RE: 6/2023/2030/COND - 71 Station Road Cuffley, EN6 4HG

Thank you for your consultation on the above site, received on 3 October 2023 for the submission of details pursuant to Condition 4 (surface water drainage), 5 (materials of external surface and refuse and recycling storage building) and 11 (secure cycle, refuse and recycling storage) on planning permission 6/2021/0456/MAJ for the (demolition of existing car showroom and erection of three storey block of flats comprising of 9 No 2 bedroom flats & 3 No 1 bedroom flats, with associated access, parking, amenity space and landscaping) which was granted permission on 12 June 2023.

Based on the information that has been provided in support of application 6/2023/2030/COND, the LLFA **recommends that Condition 4 is discharged.**

**PERMEABLE BLOCK PAVING DETAIL**  
SCALE: 1:25

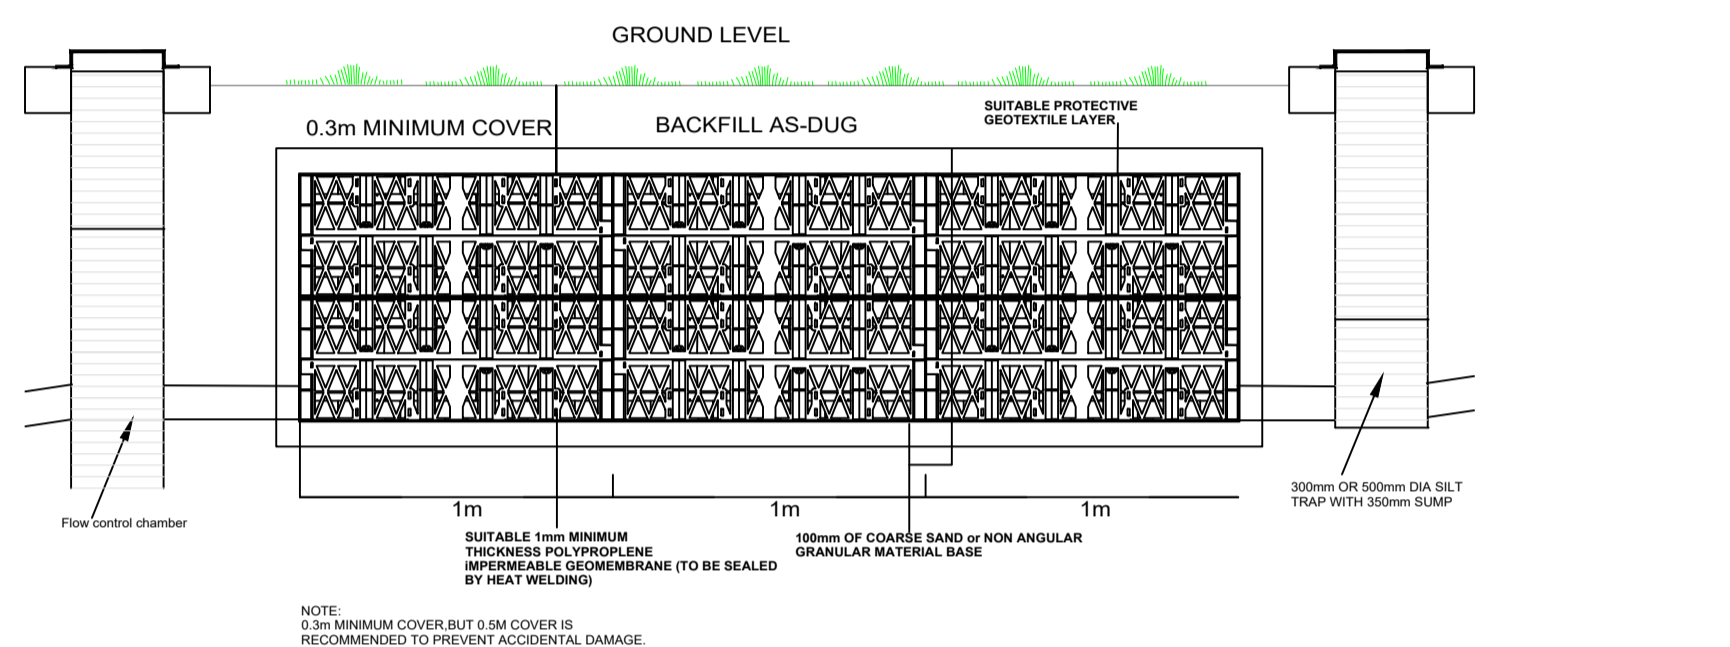
- e. Half drain times for all storage features are within 24 hours. **No further information is required.**
- f. The applicant has permeable paving within the design, providing treatment to runoff generated on the car parking area. **No further information required.**

**WAVIN CELLULAR STORAGE SYSTEM DETAIL**  
SCALE: 1:25

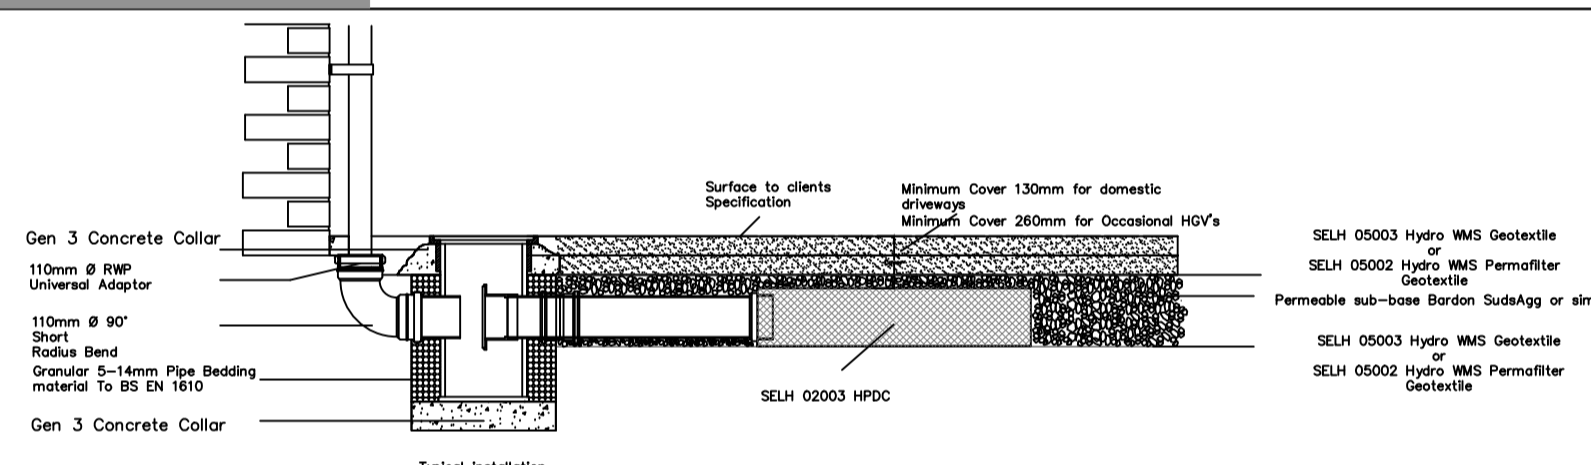
- g. We understand that silt traps have been included in the design details (cross section) of the waving cellular storage system for protection of tanked elements on DWG no. 2592-05, Rev C dated 02 February 2021. **No further information is required.**

APPR	DRAWING NO	REV
	2592-05	C

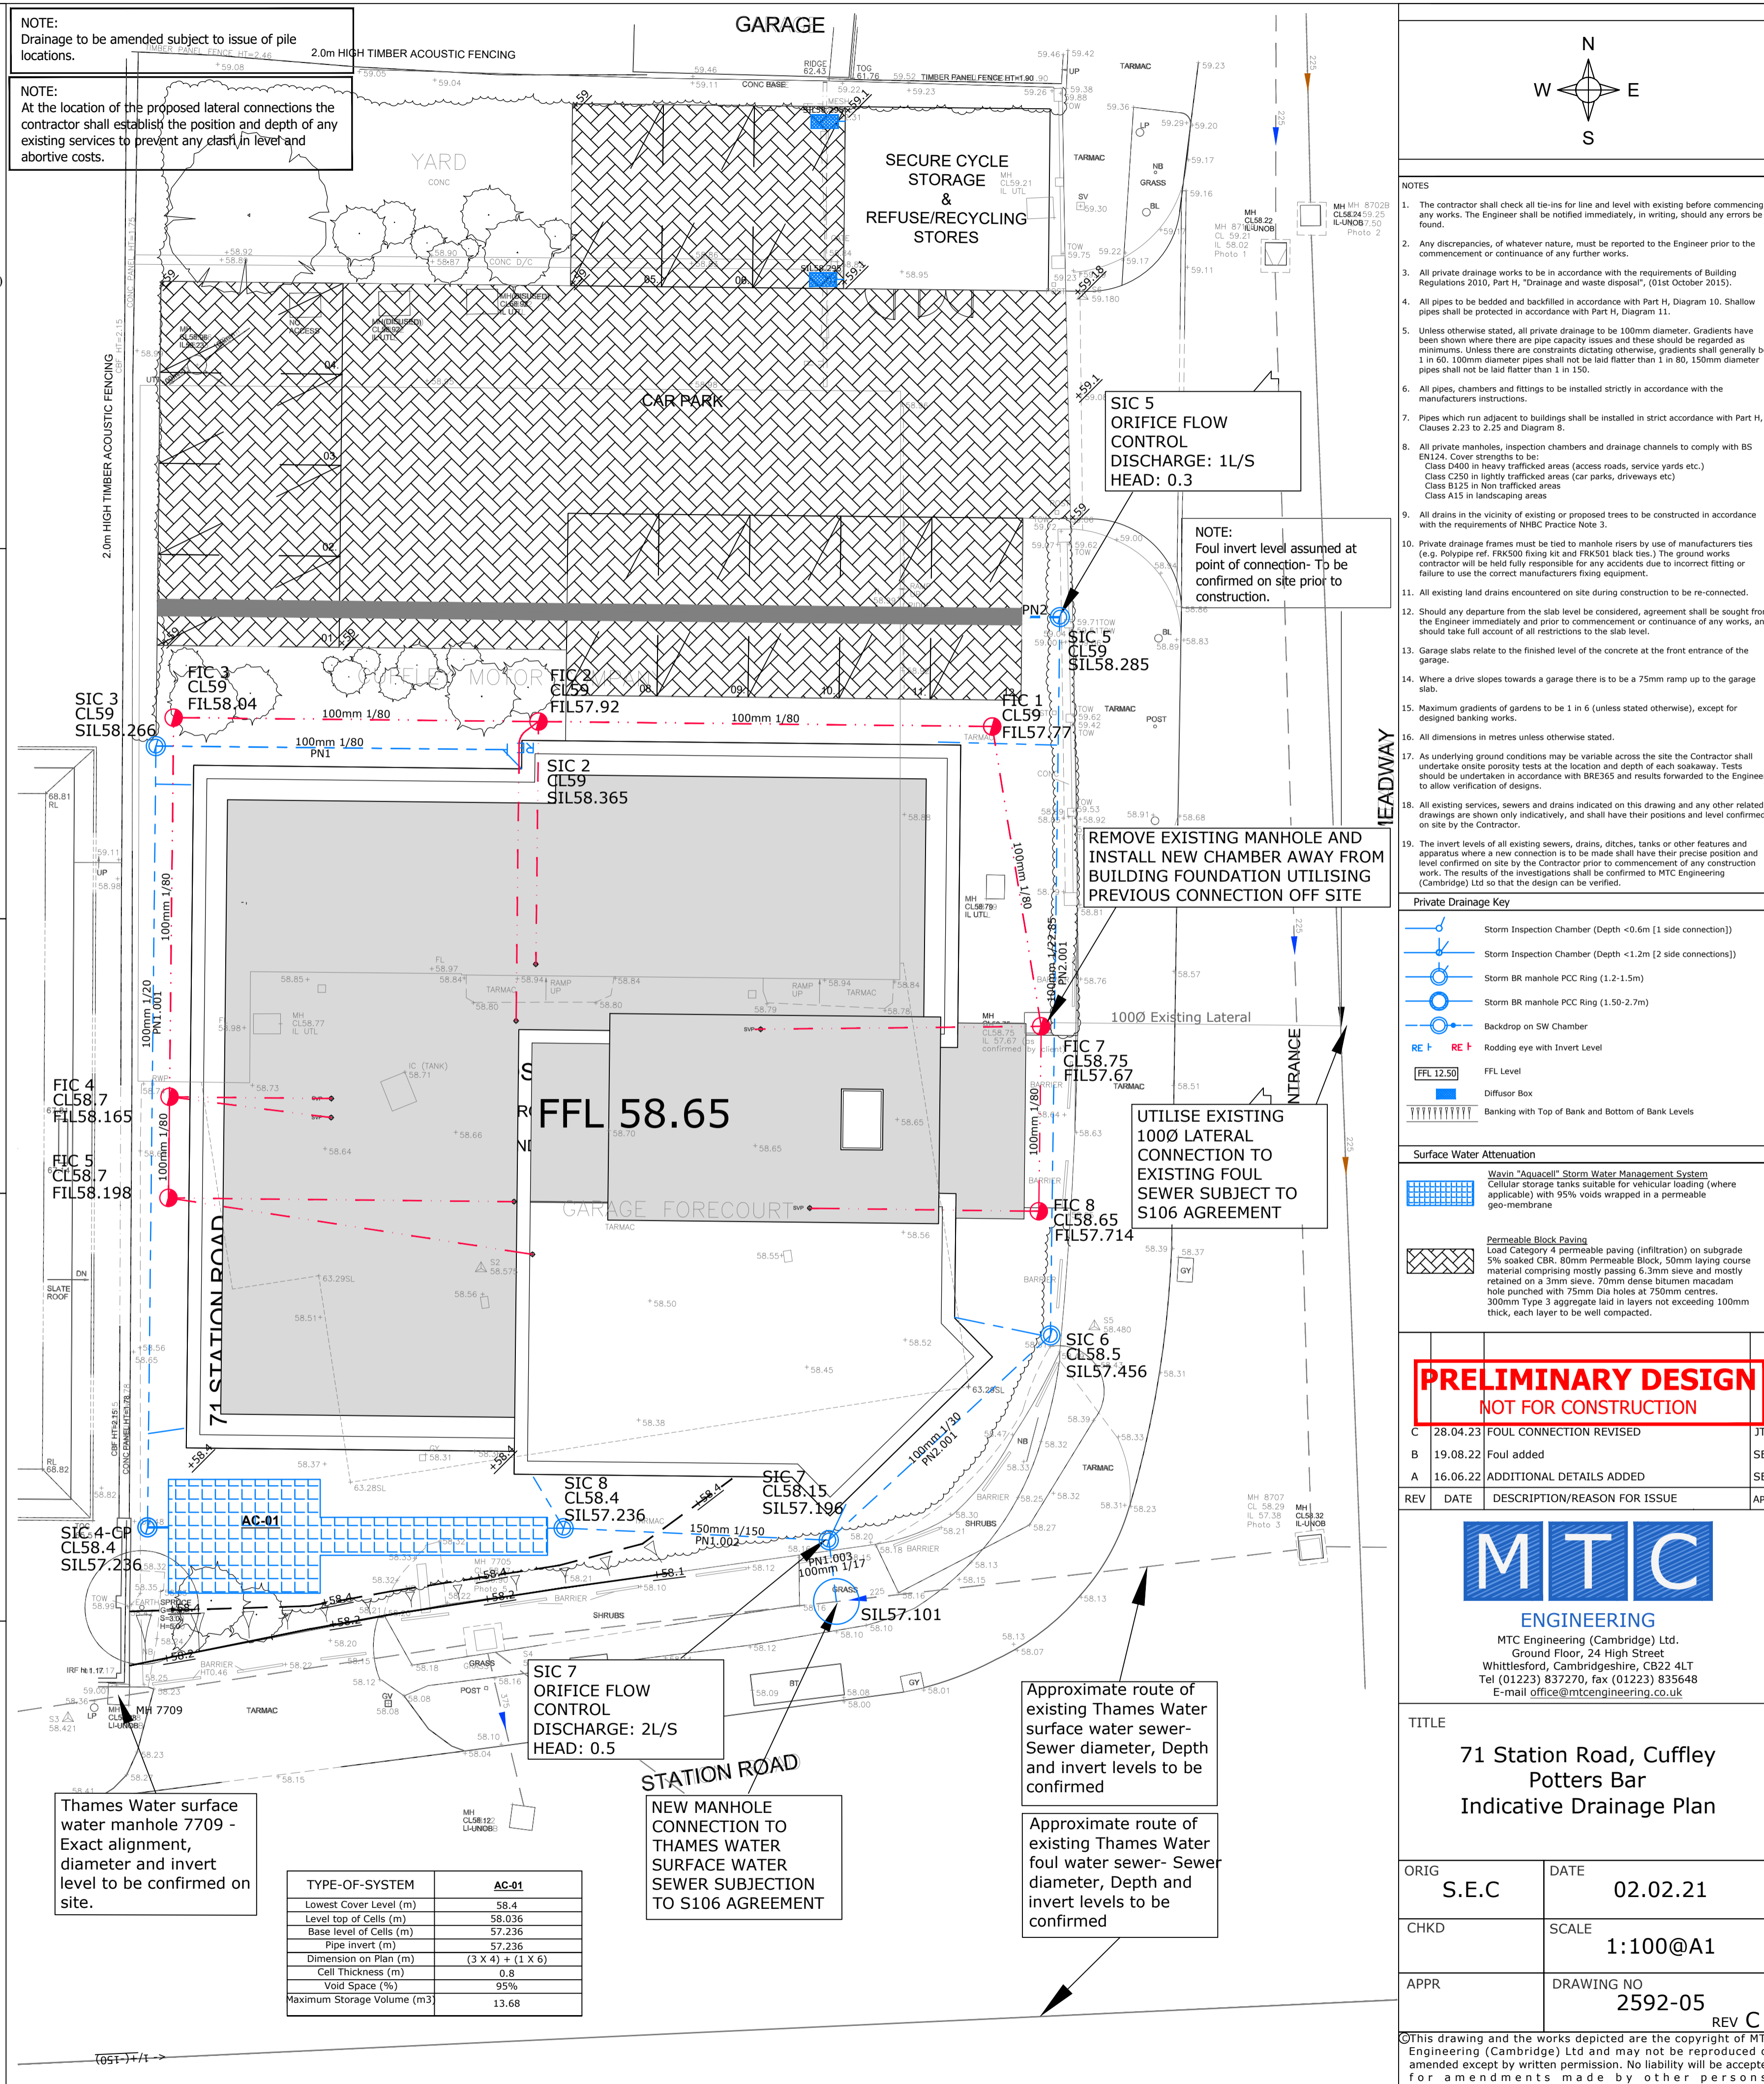
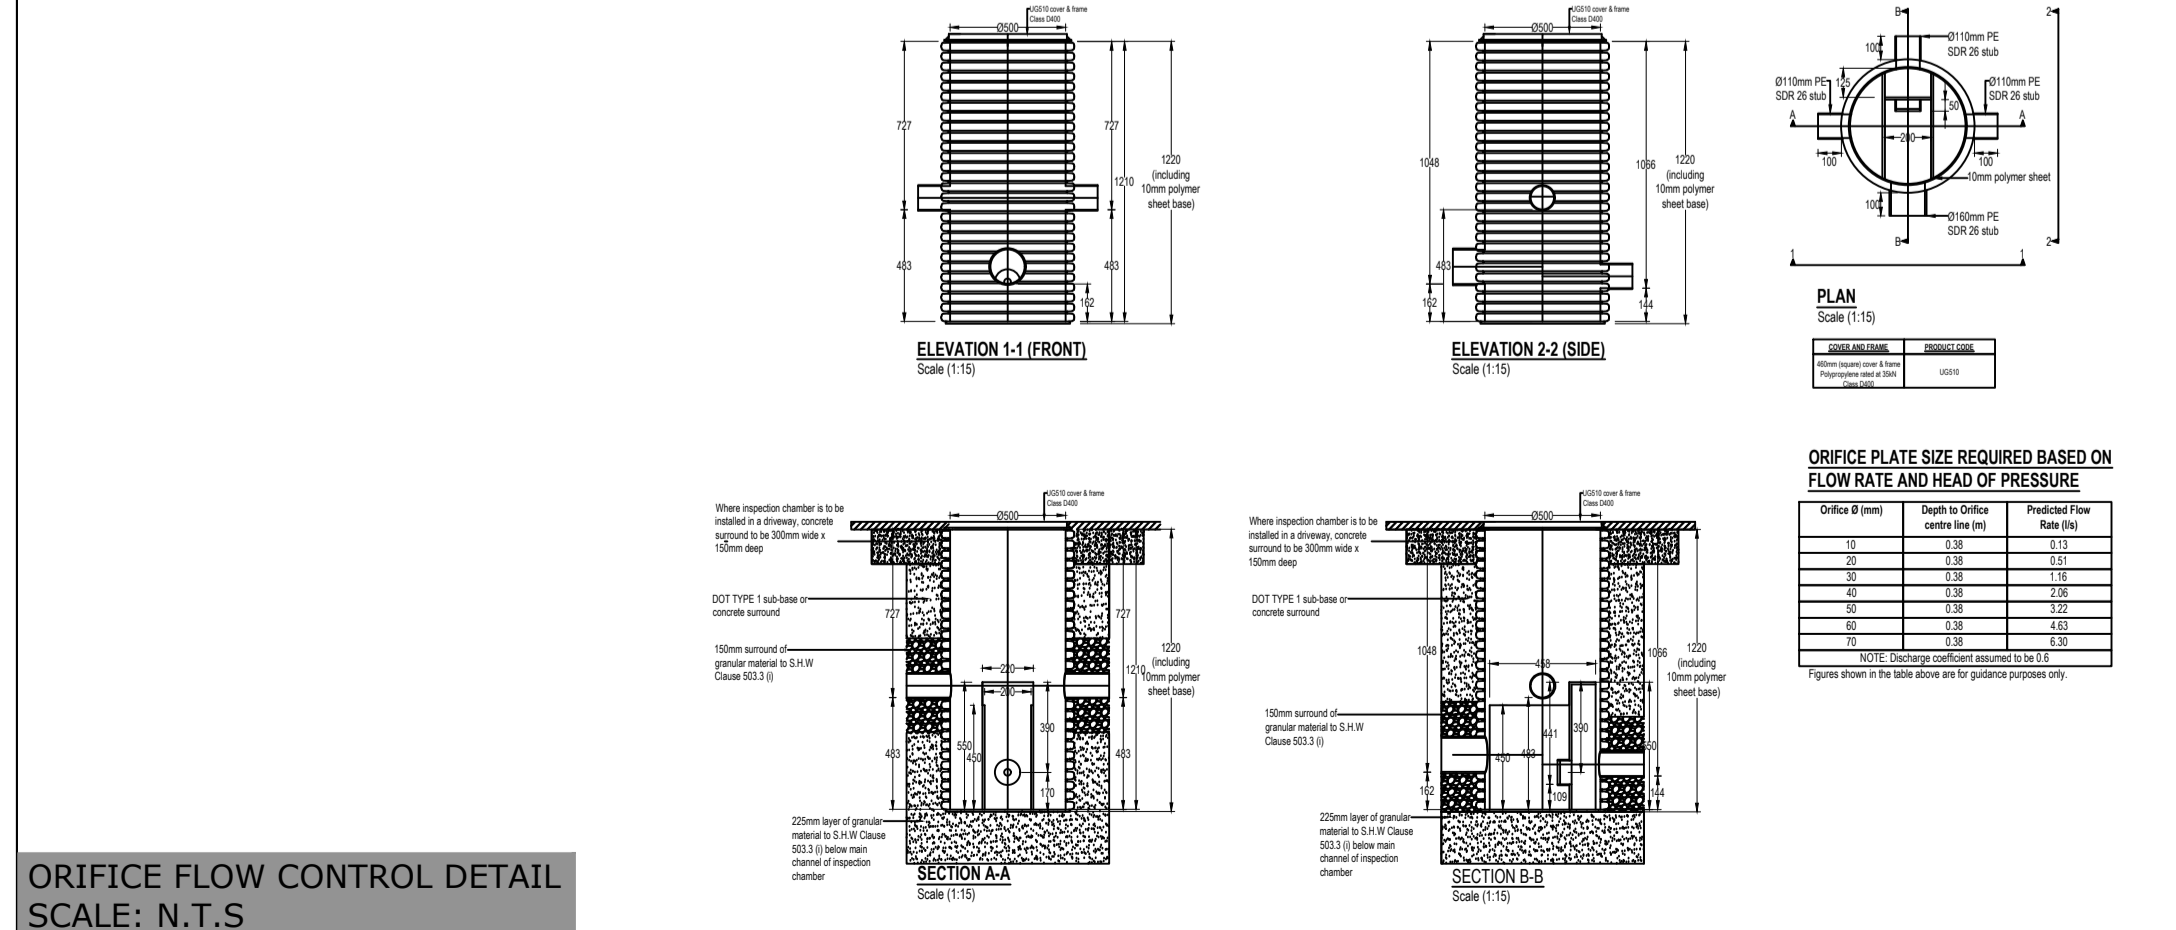
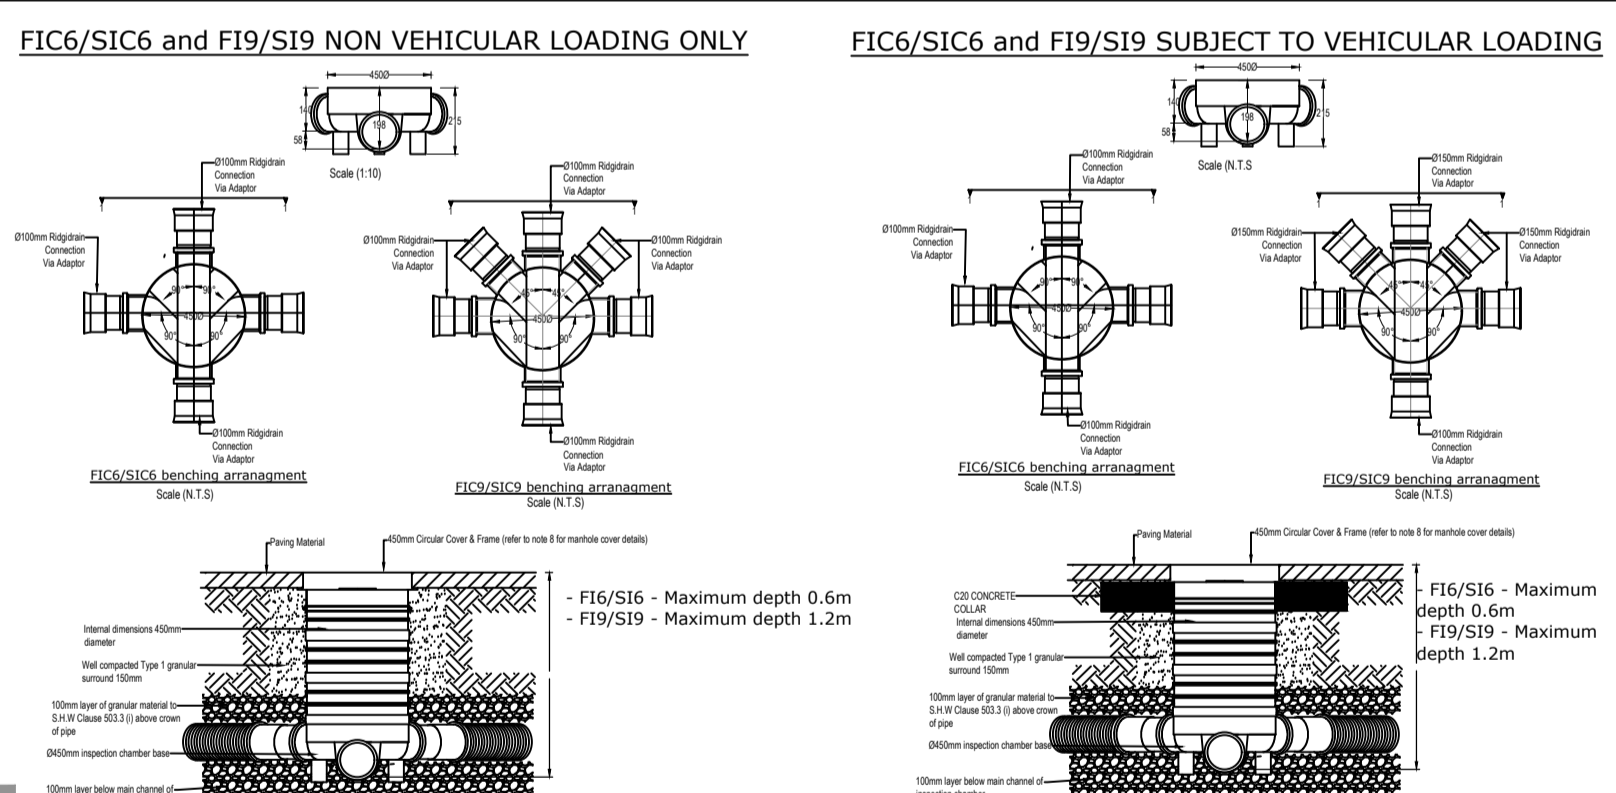
- c. Detailed engineered drawings of the proposed SuDS features have been provided in the drawing reference 2592-05 Rev C, dated 28 April 2023. **No further information required**, however please see informative at the end of this letter.

Regarding part C of Condition 4, we recommend that some further details could be provided at this stage. As a discharge of condition application, it would be beneficial for the applicant to confirm the route of the Thames Water surface water sewer as it should be known at this stage. Its alignment, diameter and invert level should be understood at this stage in the process.
